Application for non-material amendment following a grant of permission relating to Planning Consent EG/38/15/PL at 97 Barnham Road Eastergate West Sussex PO22 0EQ

The application consists of;
Your application form
Drawings as approved following previous NMA;
Location & Site Layout Plans 1220/13/P/01C
Site Layout Plan and Site Section 1220/13/P/04B
Proposed Plans and Elevations 1220/13/P/06

Drawings as amended;
Location & Site Layout Plans 1220/13/P/01D
Site Layout Plan and Site Section 1220/13/P/04E
Proposed Plans and Elevations 1220/13/P/06B

Drg No: 1220/13/P/06B

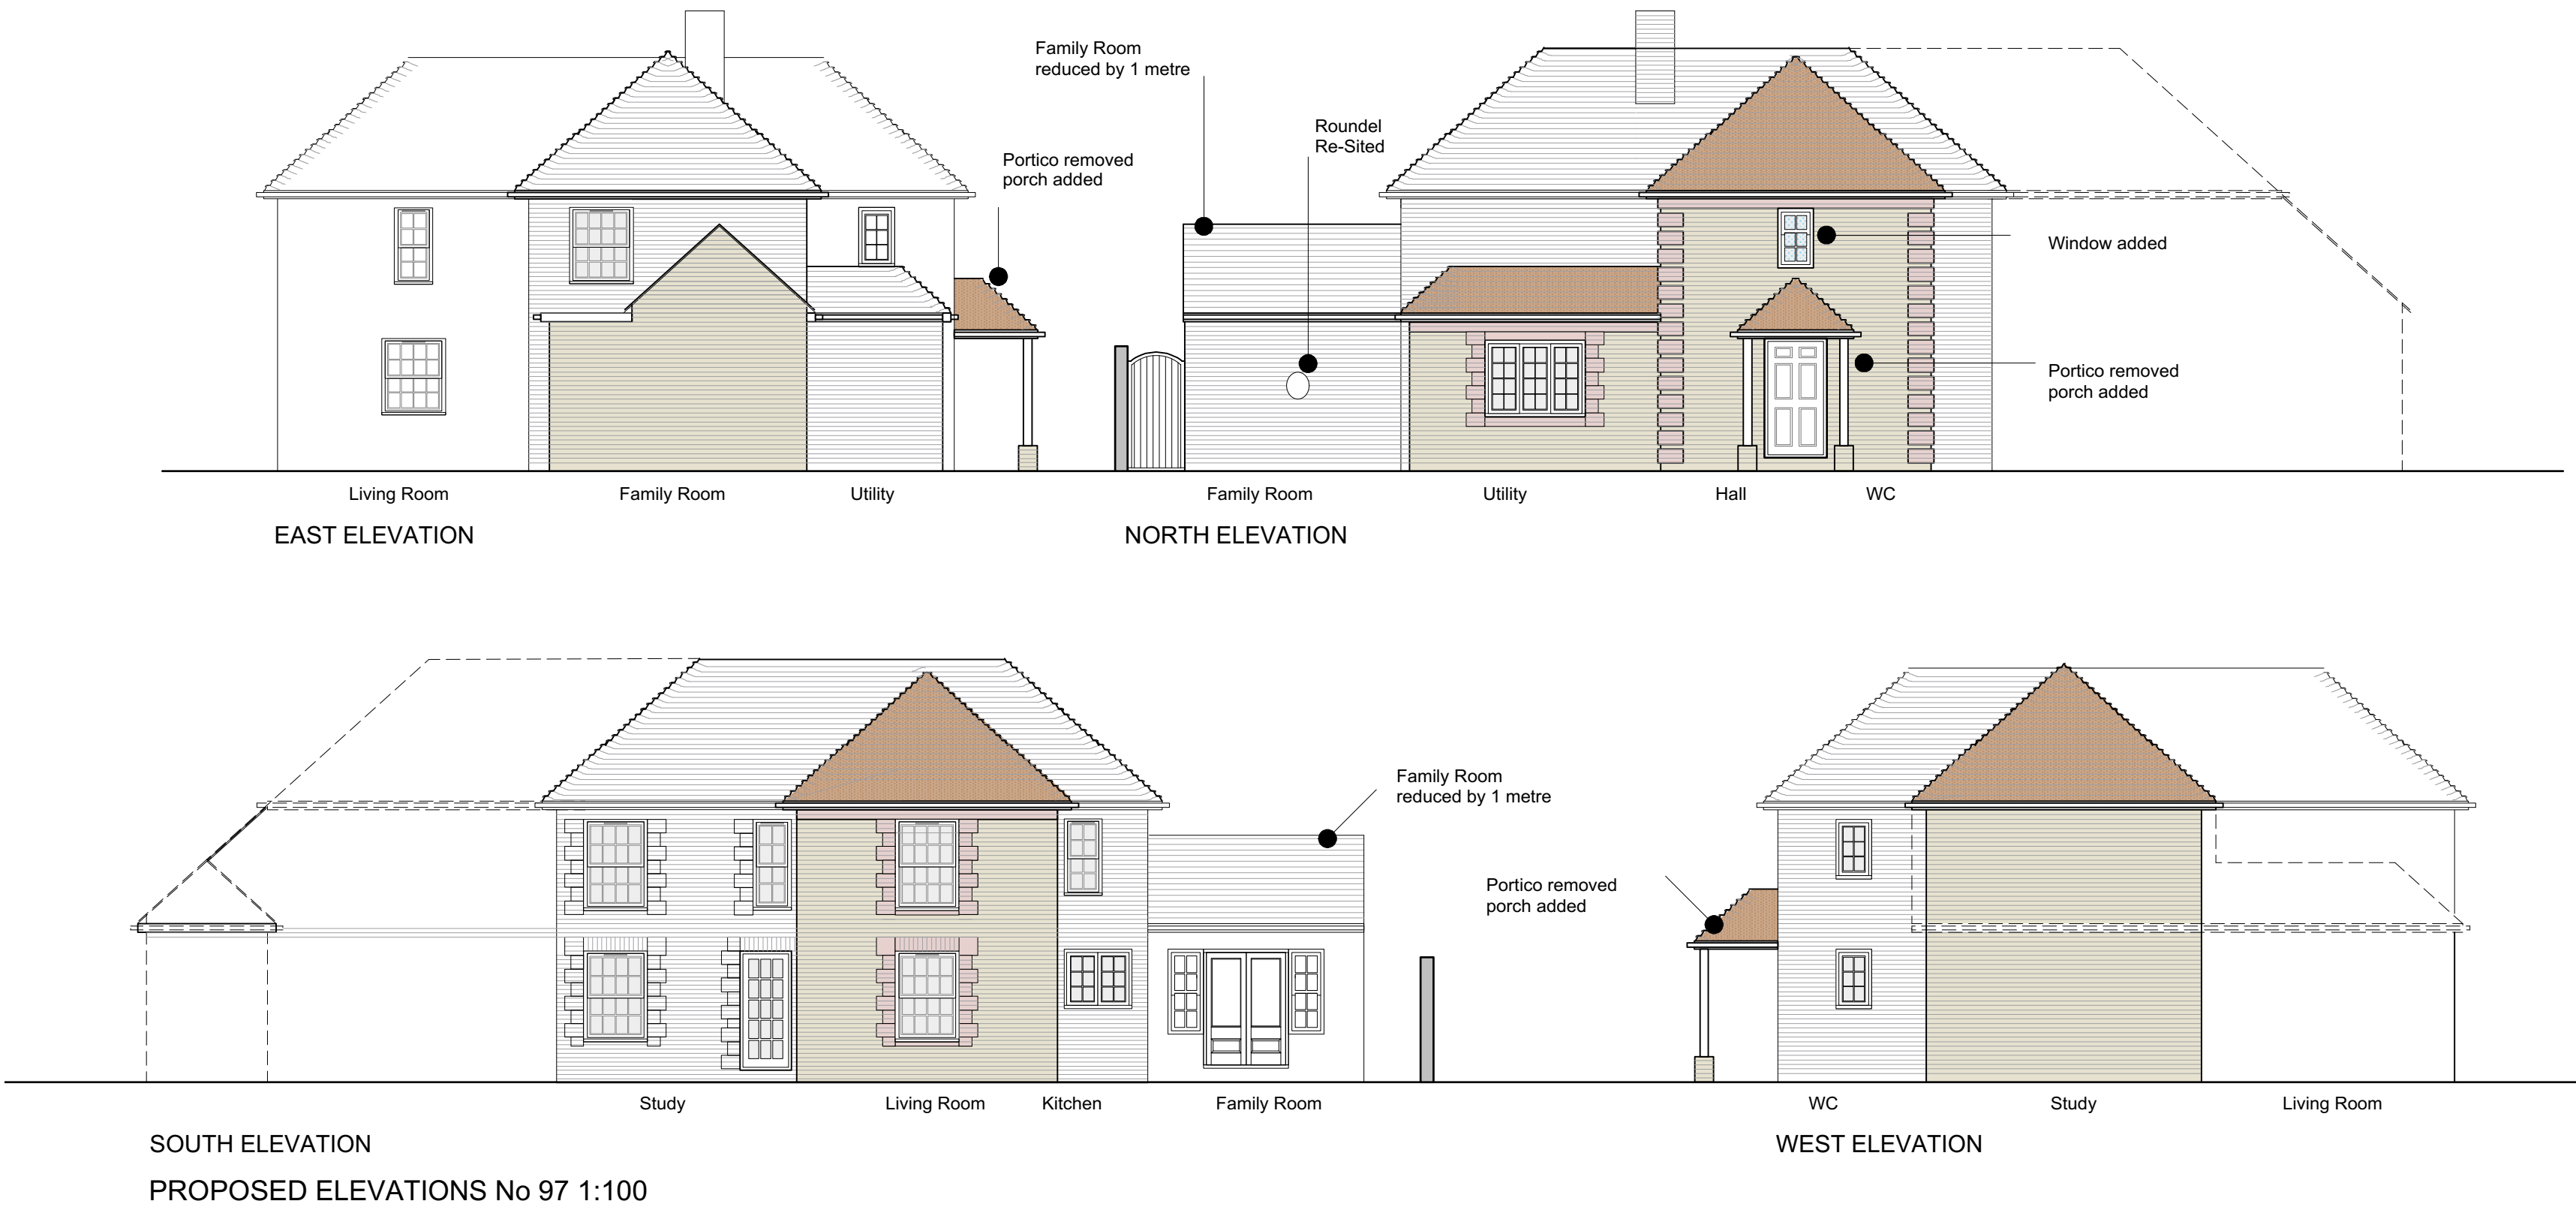
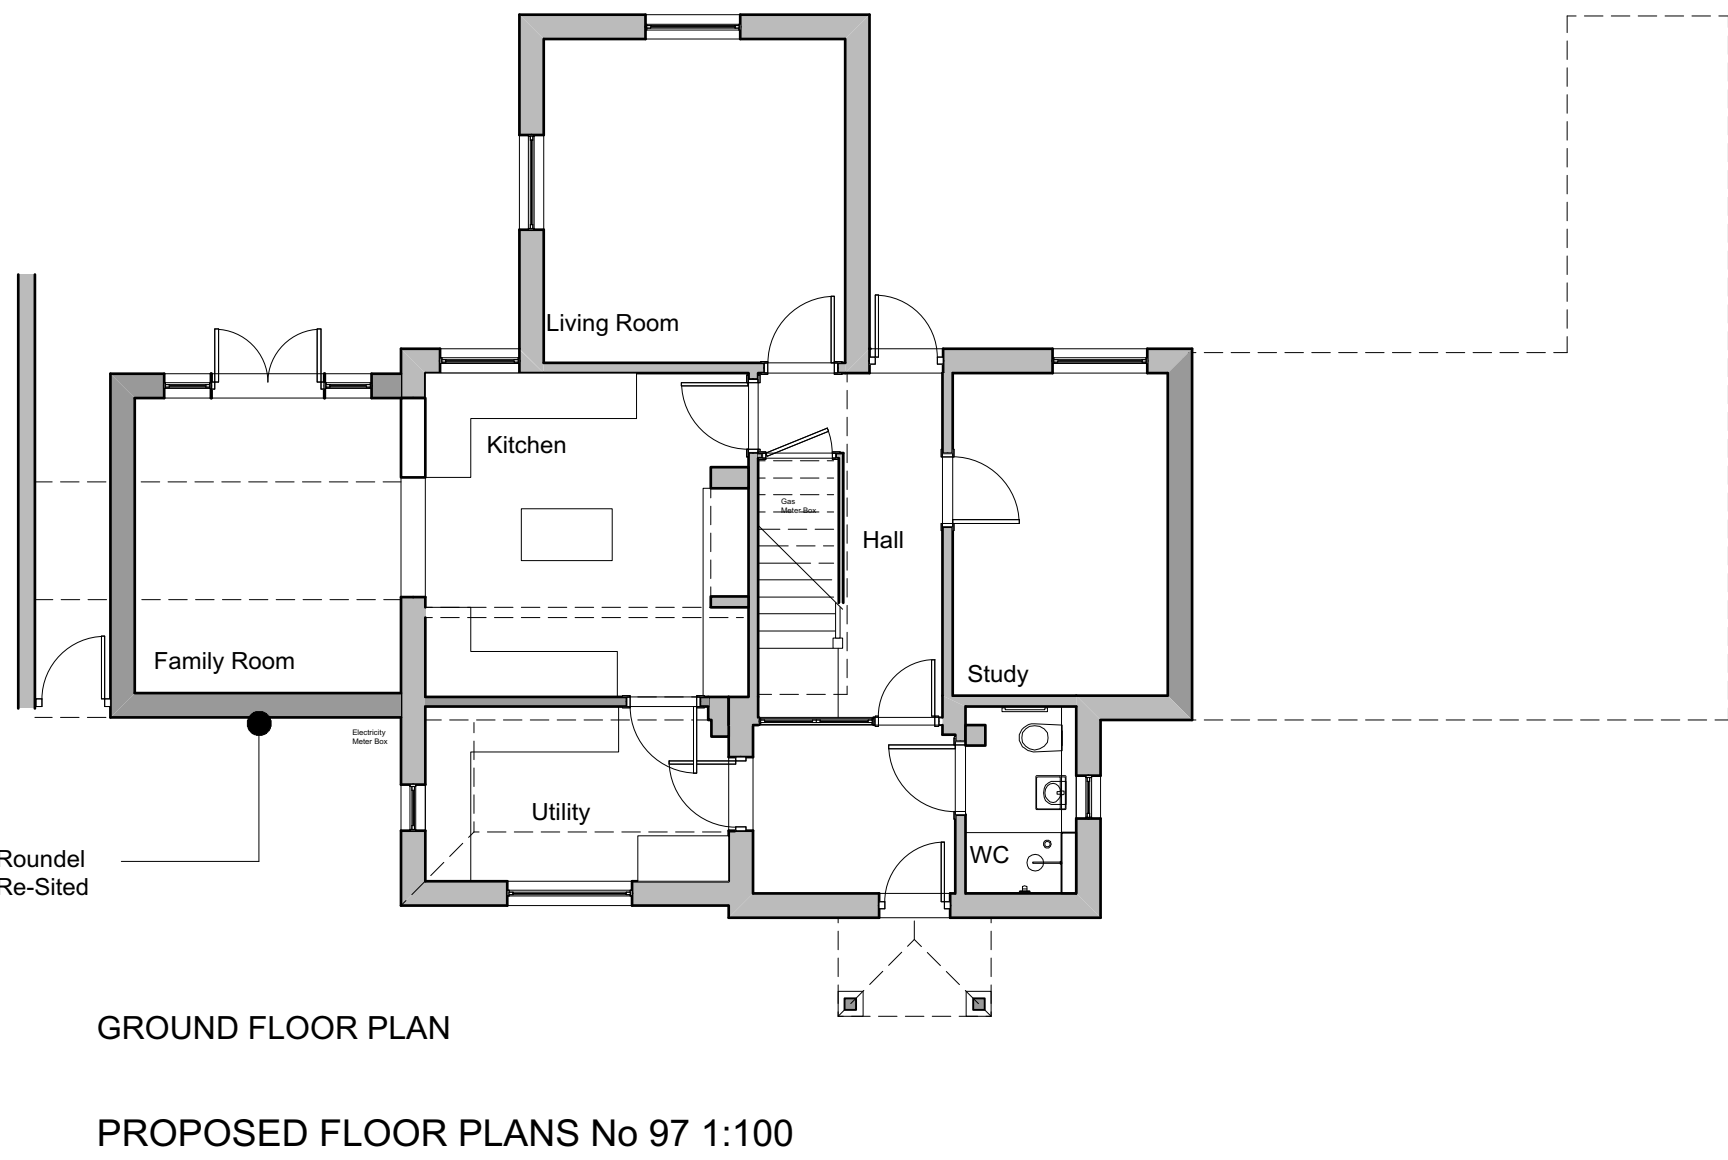
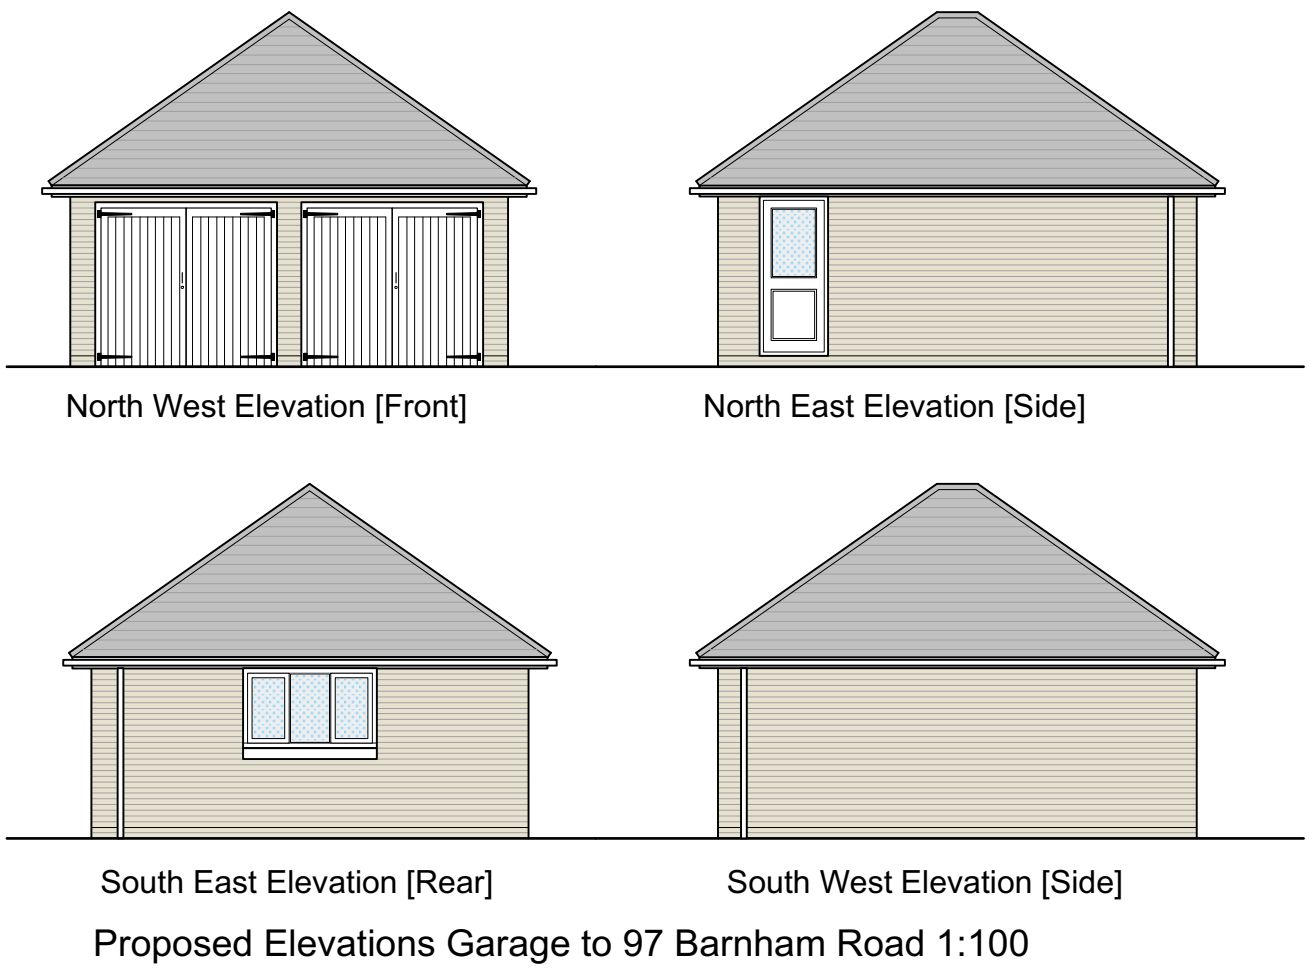
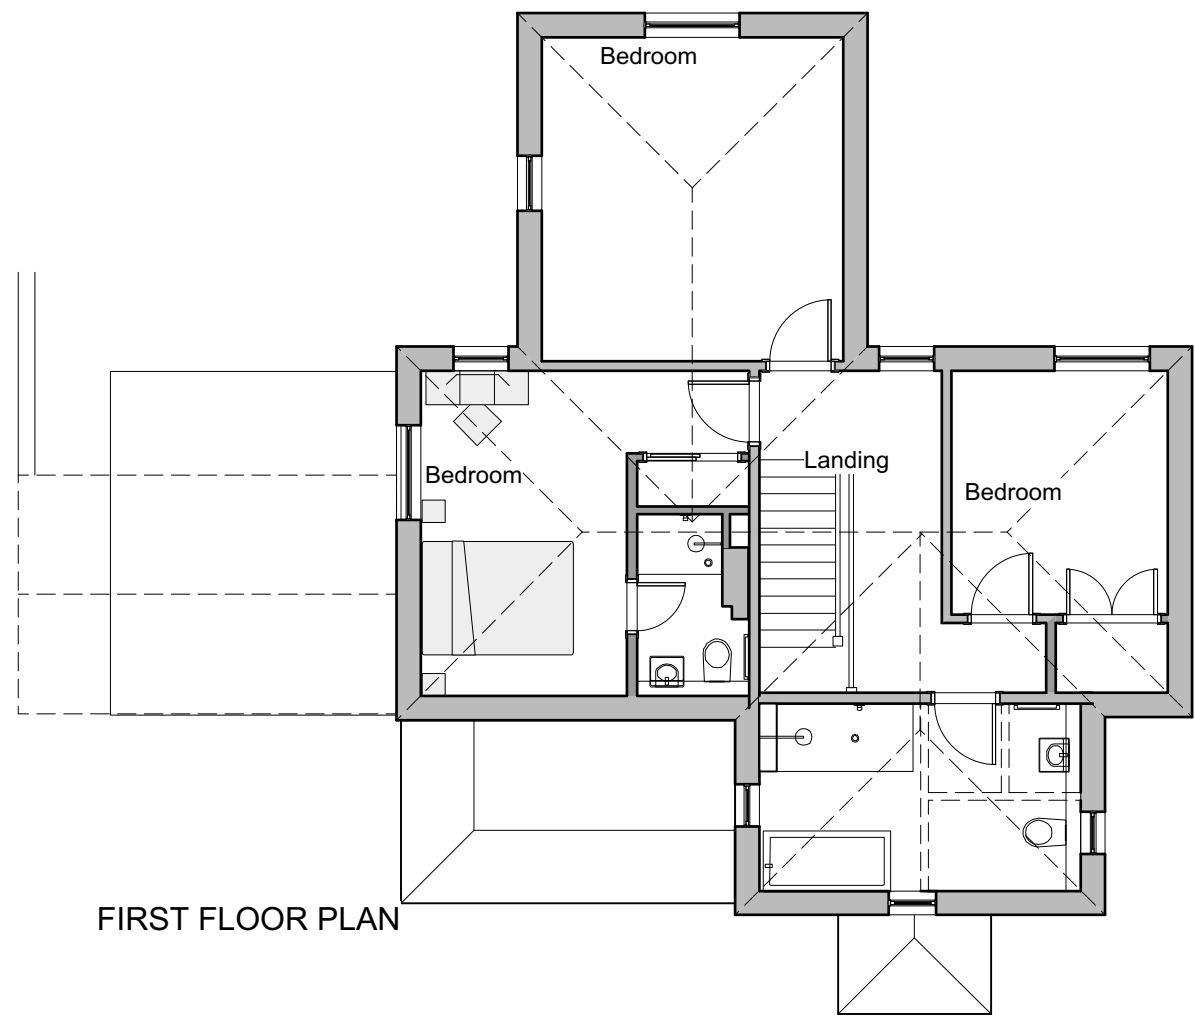
Firstly, to reduce size of single storey side extension to south east elevation to leave a separation distance of one metre from the adjoining property. Refer to drawings, 1220/13/P/01D, 1220/13/P/04E, and 1220/13/P/06B.

Secondly, to add an additional window to the principal elevation at first floor level to serve a bathroom. The decorative roundel will be re-sited within the blank facade to the side extension. Refer to drawing, 1220/13/P/06B.
